The Member Secretary,  
Madras Metropolitan  
Development Authority,  
Thalamuthu-Natarajan Building,  
No.8, Gandhi Irwin Road,  
MADRAS: 600 008

-----  
Lr.No. **D.Die. A1/20876/89** dated **17.1.90.**

Sub: MMDA - Planning permission - Construction of  
residential building in Plot No.3 at S.No.105/  
pt of Lakshmi Nagar, Porur village - Approval  
Regarding.

SITE PLAN & G.F. PLAN

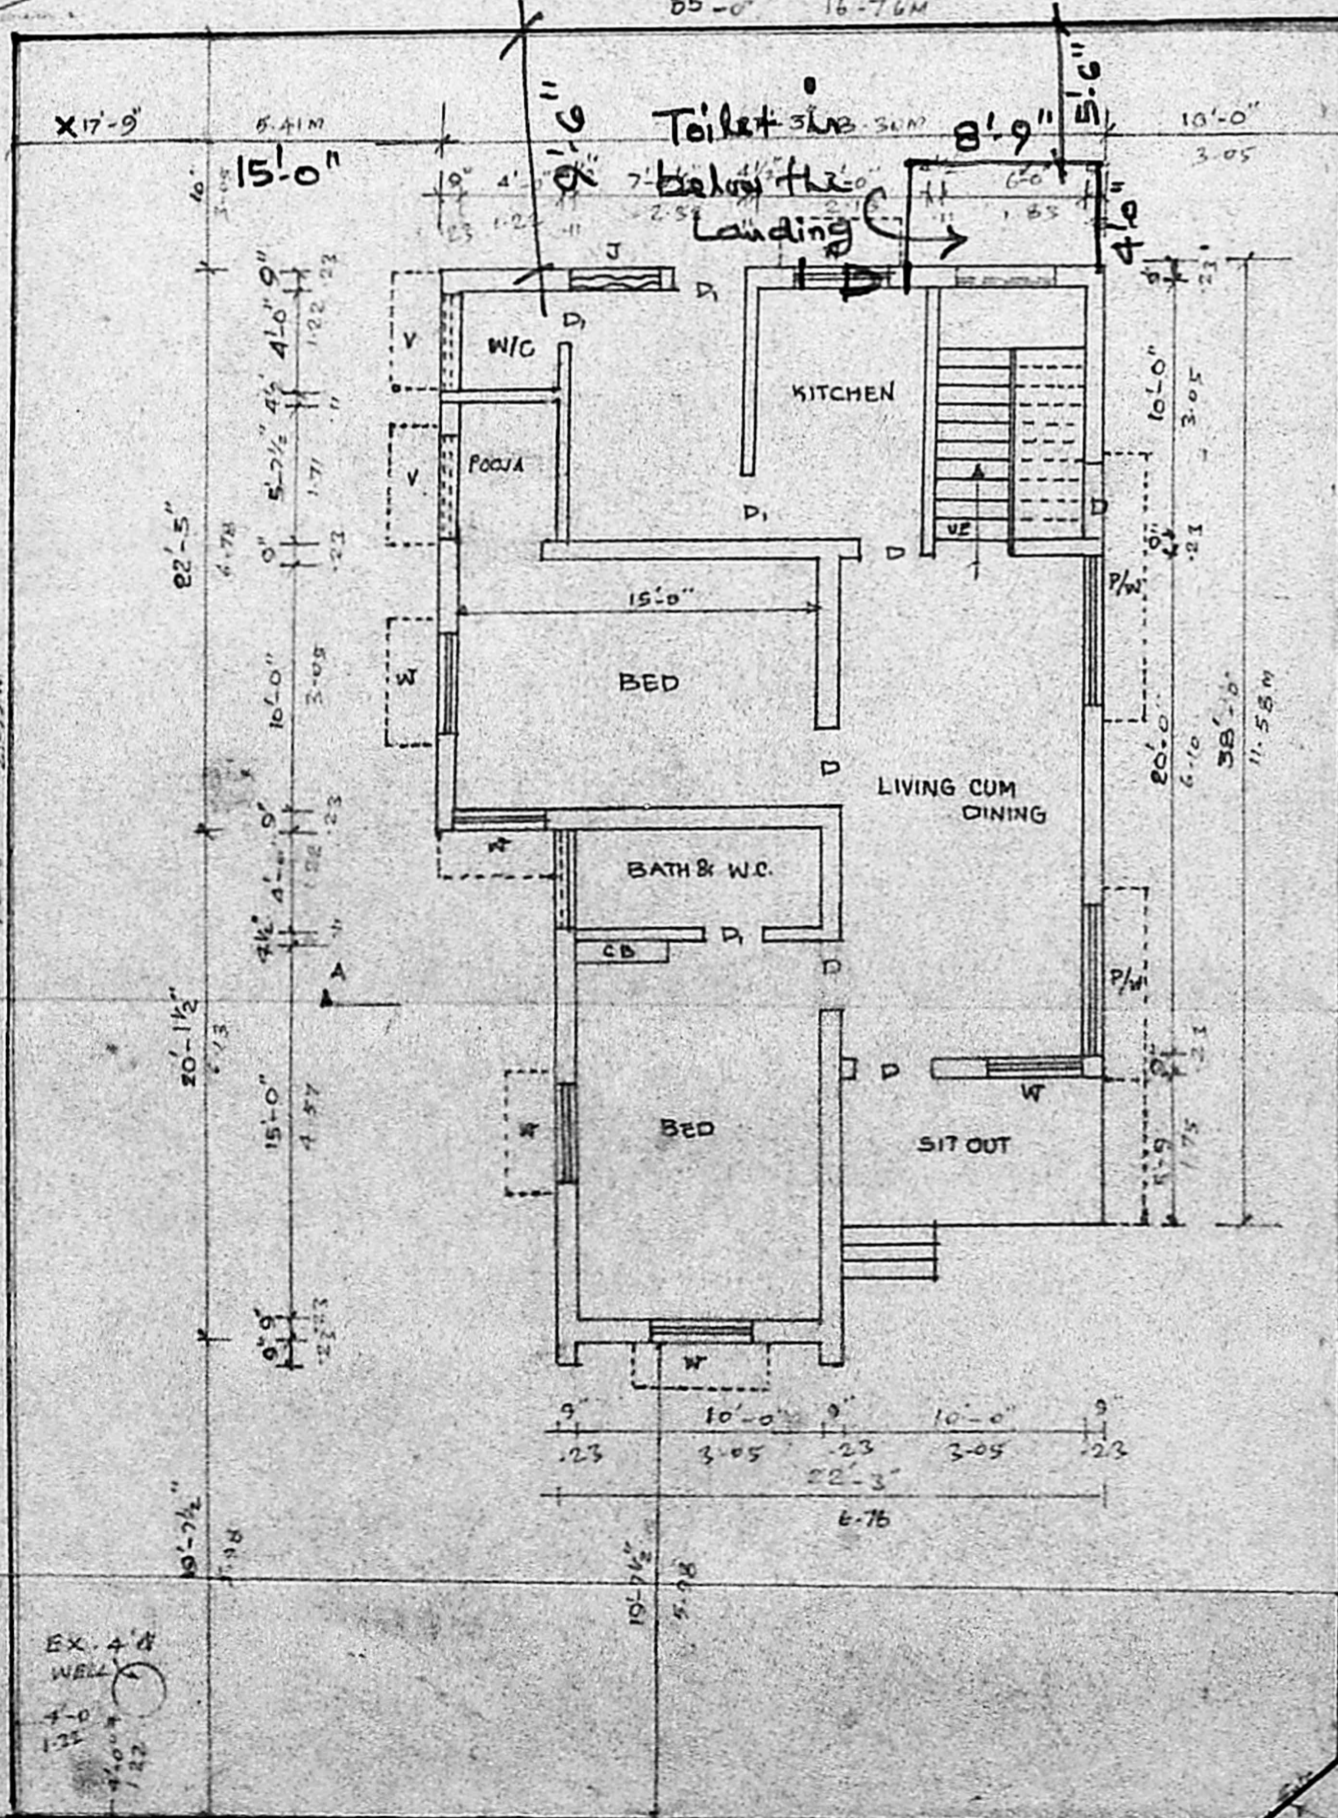
**\* by relaxing the violation of Rear Set Back**
